# THURROCK COUNCIL

Application for a Non-Material Amendment Following a Grant of Planning Permission

Proposed replacement dwelling of a contemporary design with associated hard and soft landscaping

22/00652/FUL

Drawing **Proposed North and
South Elevations**

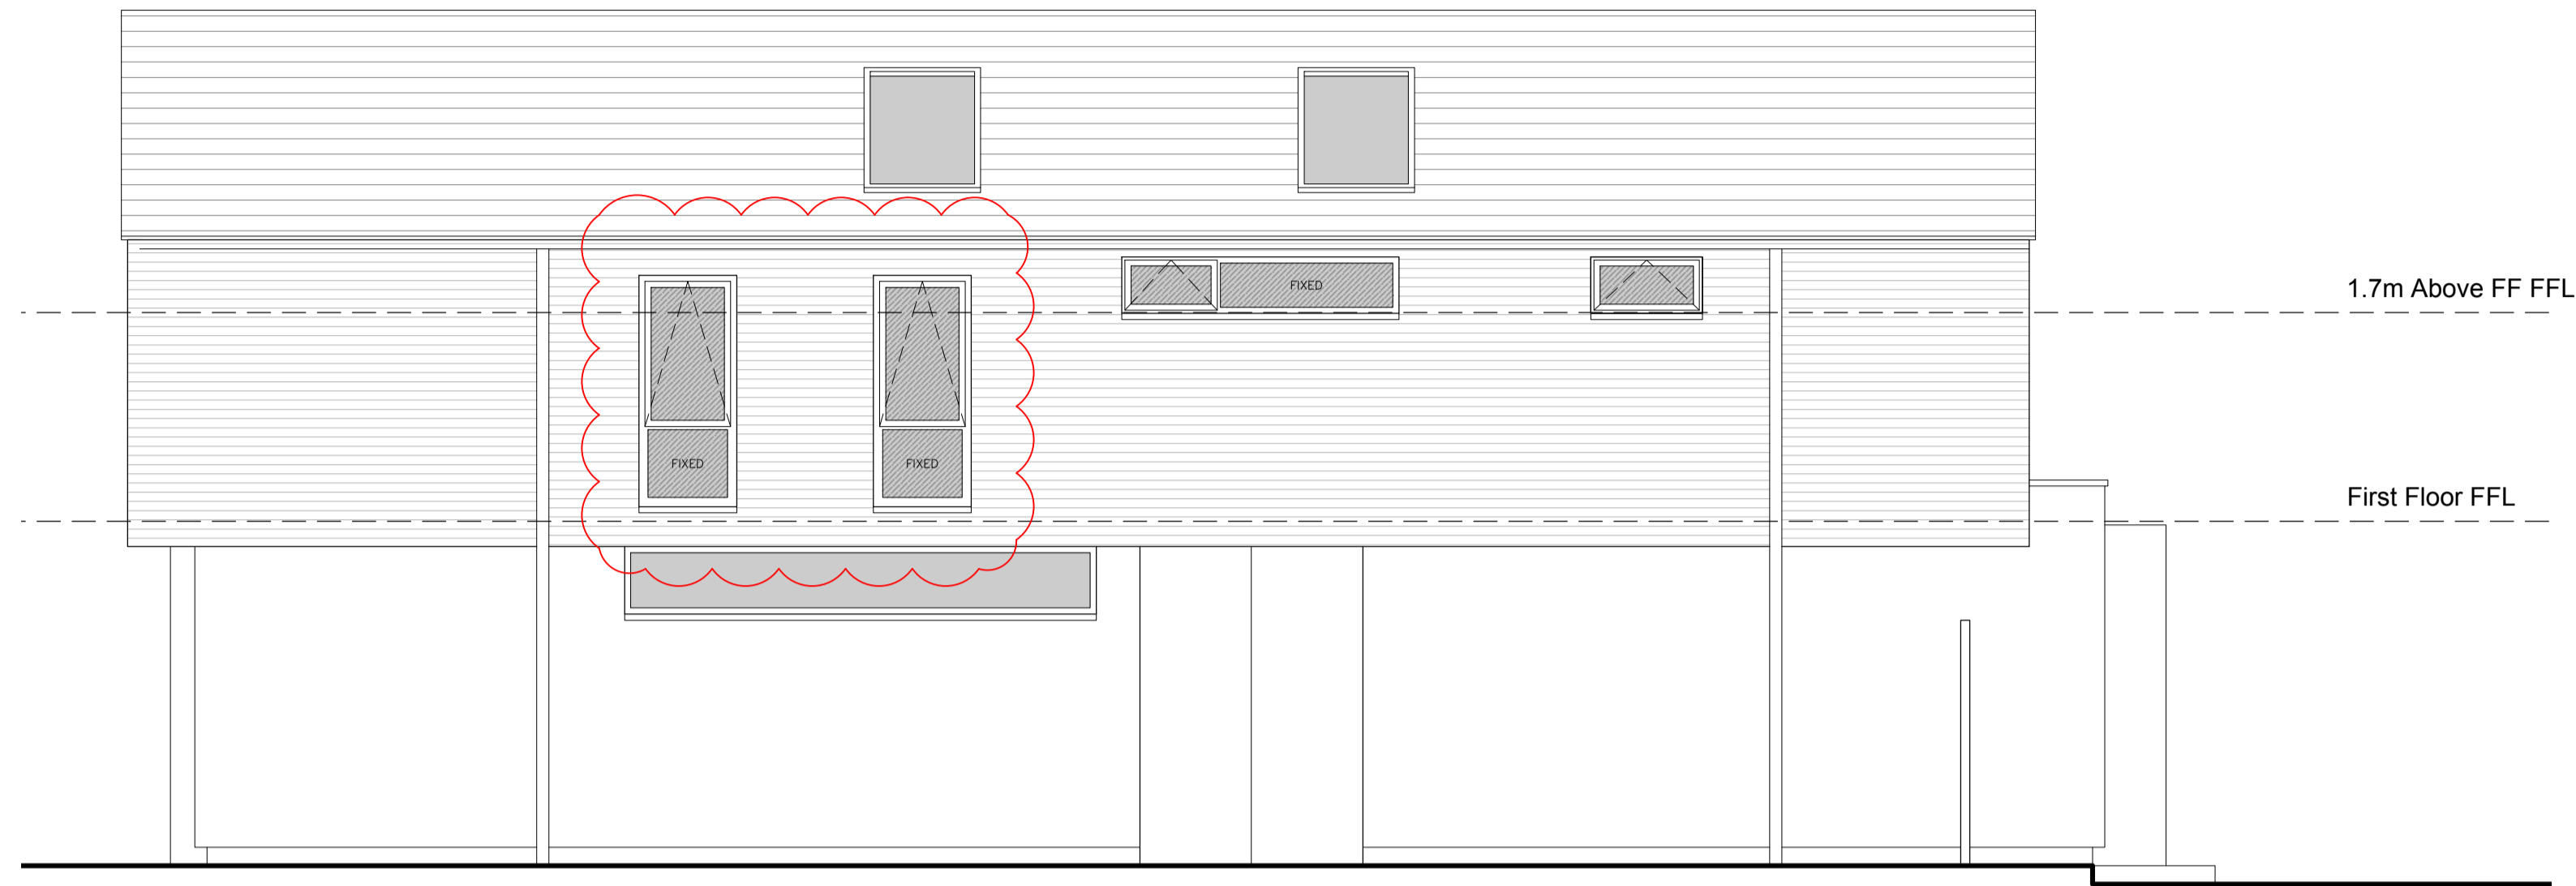
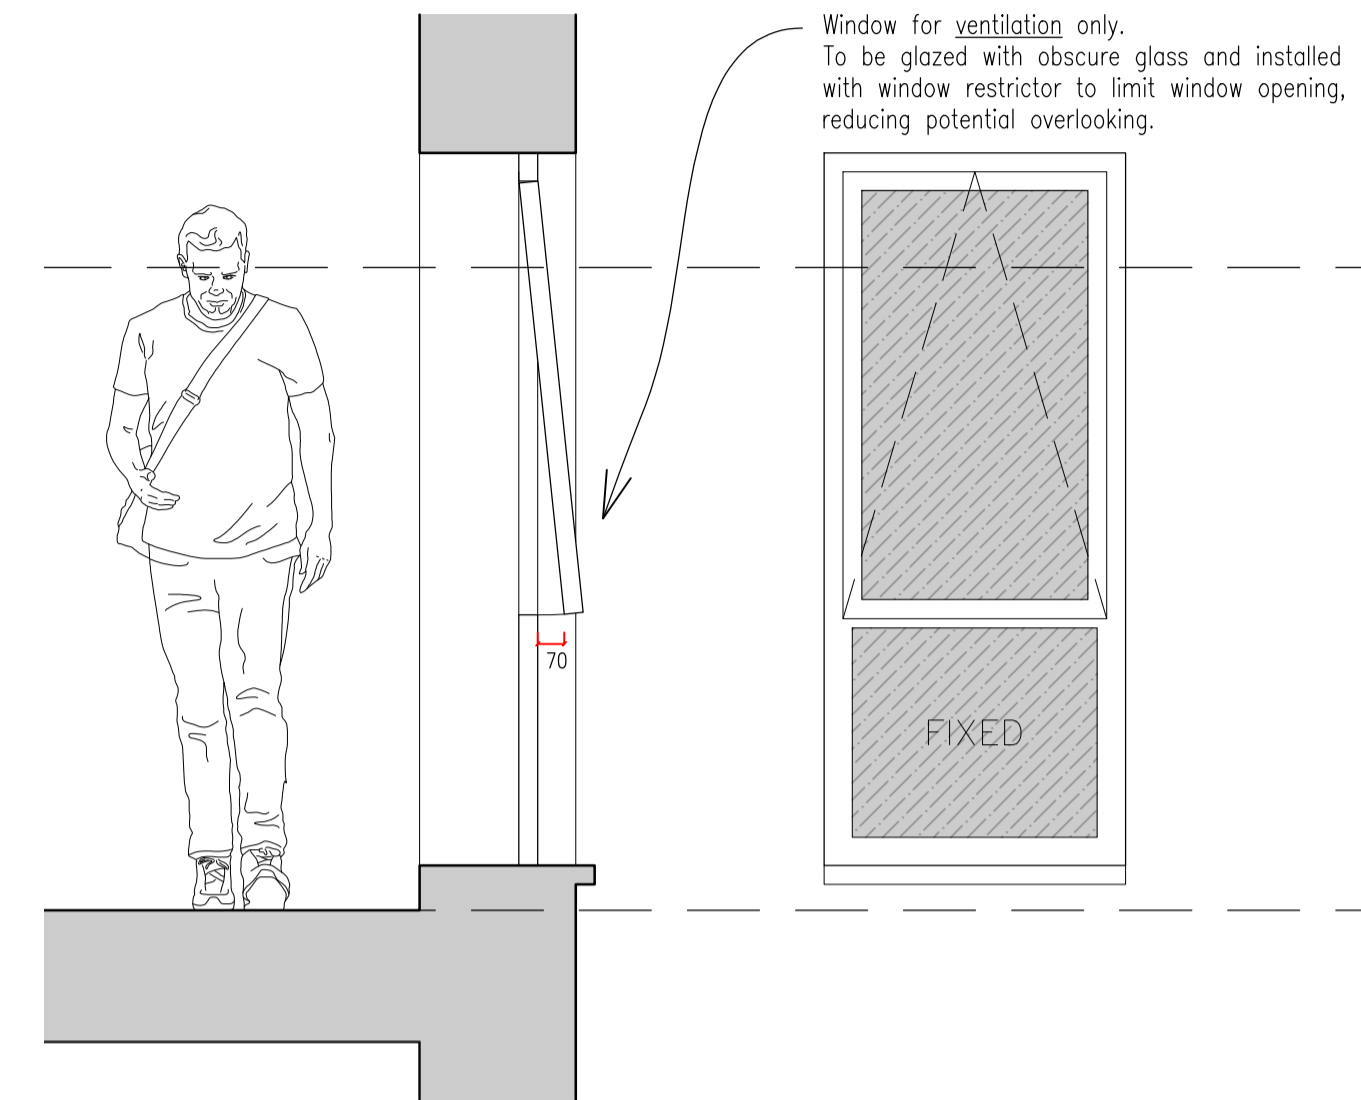
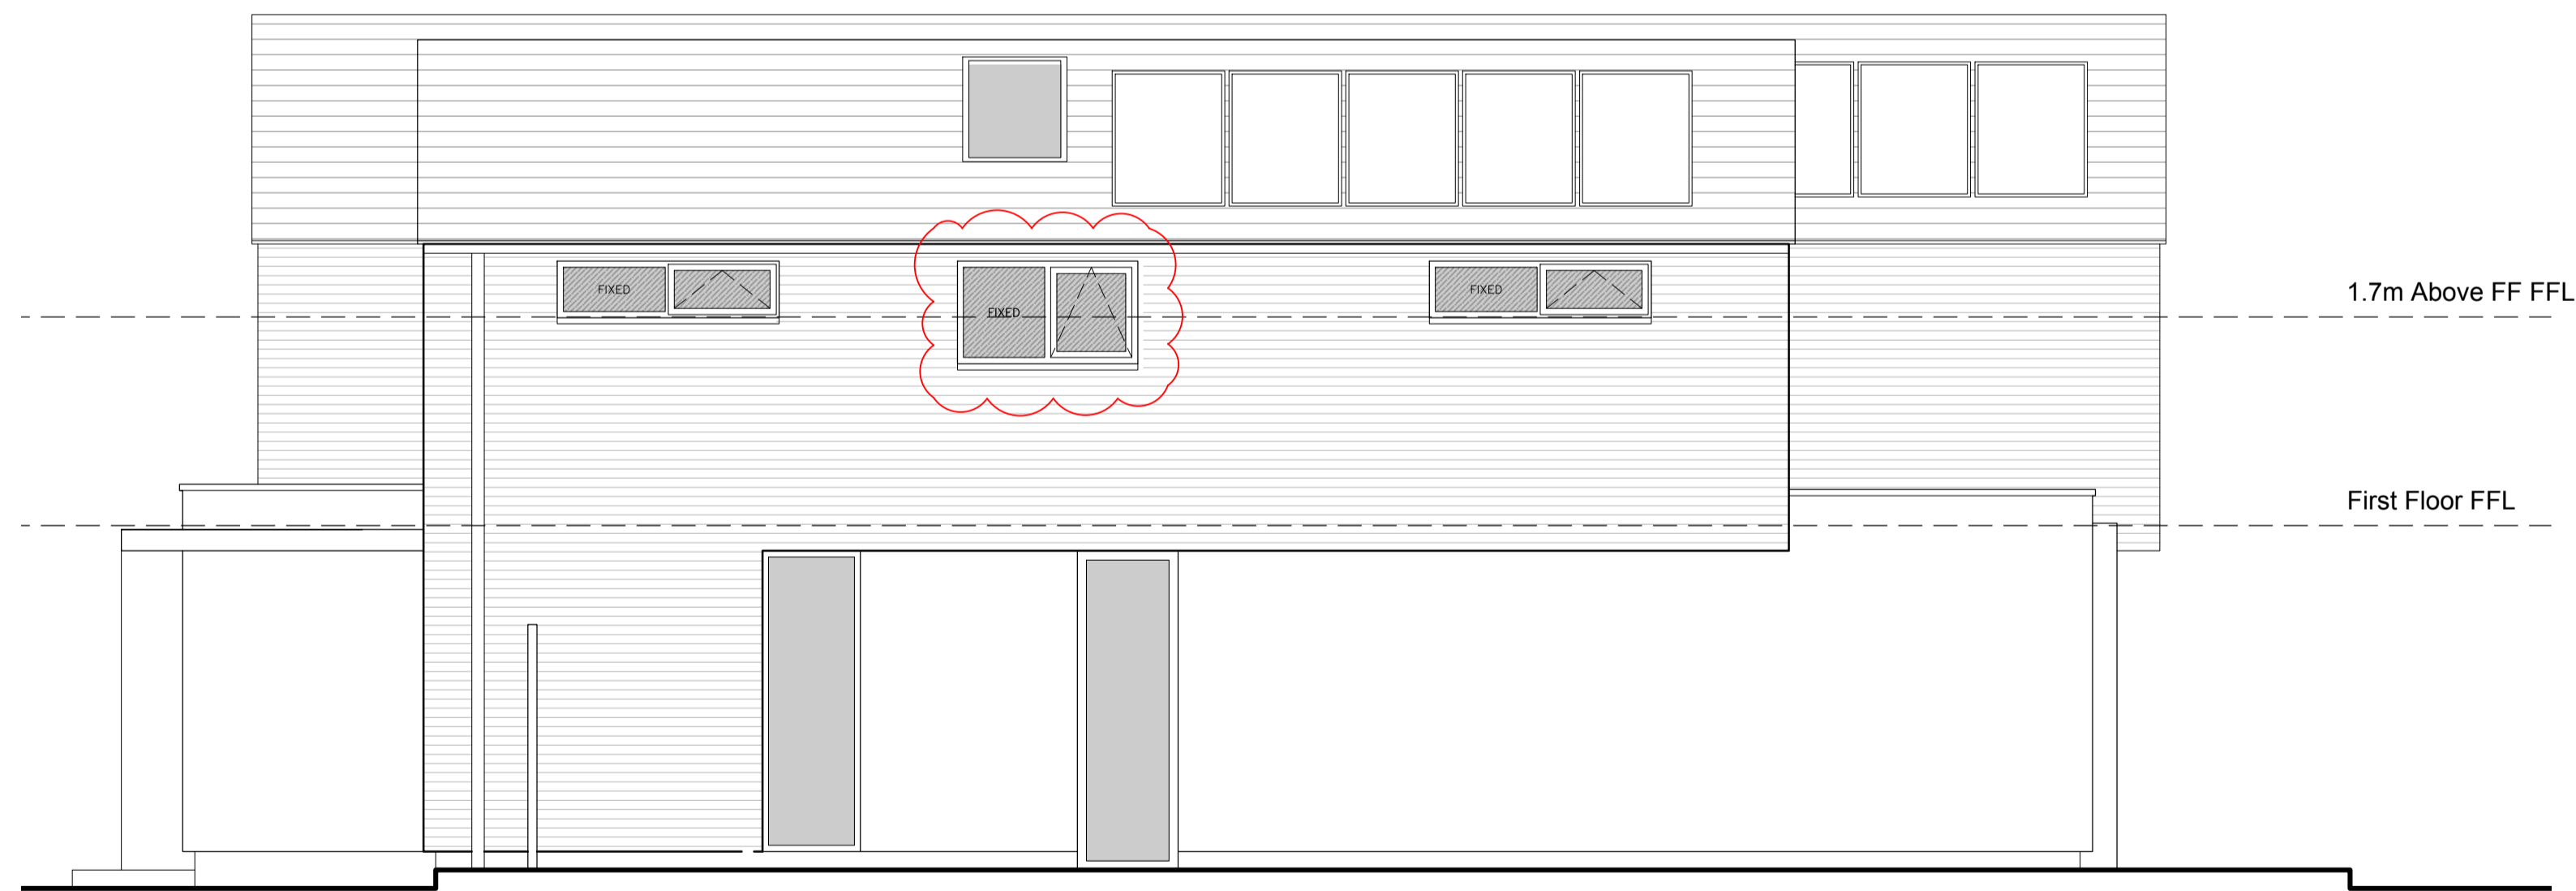
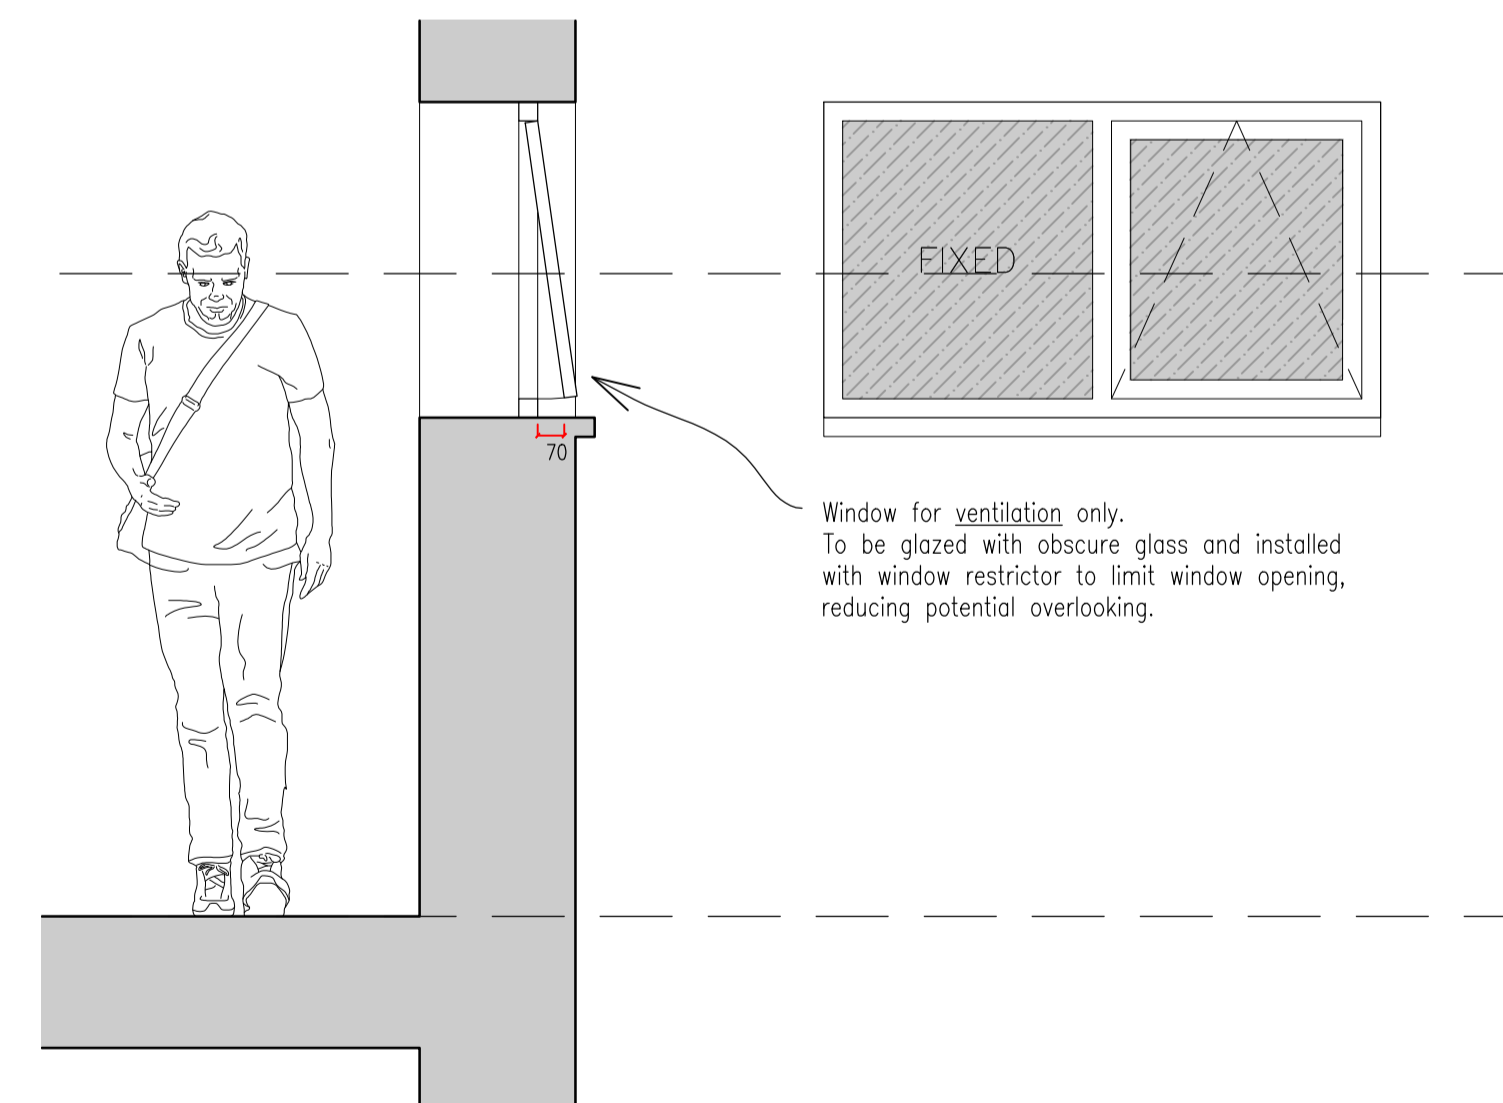
Modification of window configurations due to a planning condition imposed on the initial planning approval, following a previously approved application for the discharge of this condition.

Please see following description of Planning Condition 10: "Prior to the first occupation of the dwelling hereby permitted, the first floor windows in both the north and south elevations shall be glazed with opaque glass and of a non-openable design with the exception of a top hung fanlight (which shall be at least 1.7m above internal floor level) and shall be retained as such thereafter."

The project has commenced on-site, and we are unable to source the originally proposed and approved windows due to limitations regarding their opening style and weight. Consequently, we are exploring alternative window configurations that we believe, while falling outside the constraints of the planning condition, adequately address concerns regarding overlooking, which was the primary reason for the imposed condition.

The suggested window configurations harmonise with the other openings throughout the home, ensuring a uniform design language. This layout was initially proposed in the approved planning proposal, detailed in drawing RHJB\_22002\_002E\_Proposed Plans and Elevations. We believe that opting for a fan-light arrangement would disrupt the cohesive design of the house and prevent adequate room ventilation required by Building Regulations. Instead, the proposed configuration includes obscure glass in compliance with this planning condition, alongside a window restrictor limiting the aperture to 70mm, as depicted in drawing RHJB\_22002\_011B\_Proposed North and South Elevations. We are confident that any potential overlooking concerns would be minimal, especially given the placement of these windows along a side alleyway and within a transitional zone between bedroom and en-suite spaces within the home.

RHJB\_22002\_011B\_Proposed North and South Elevations
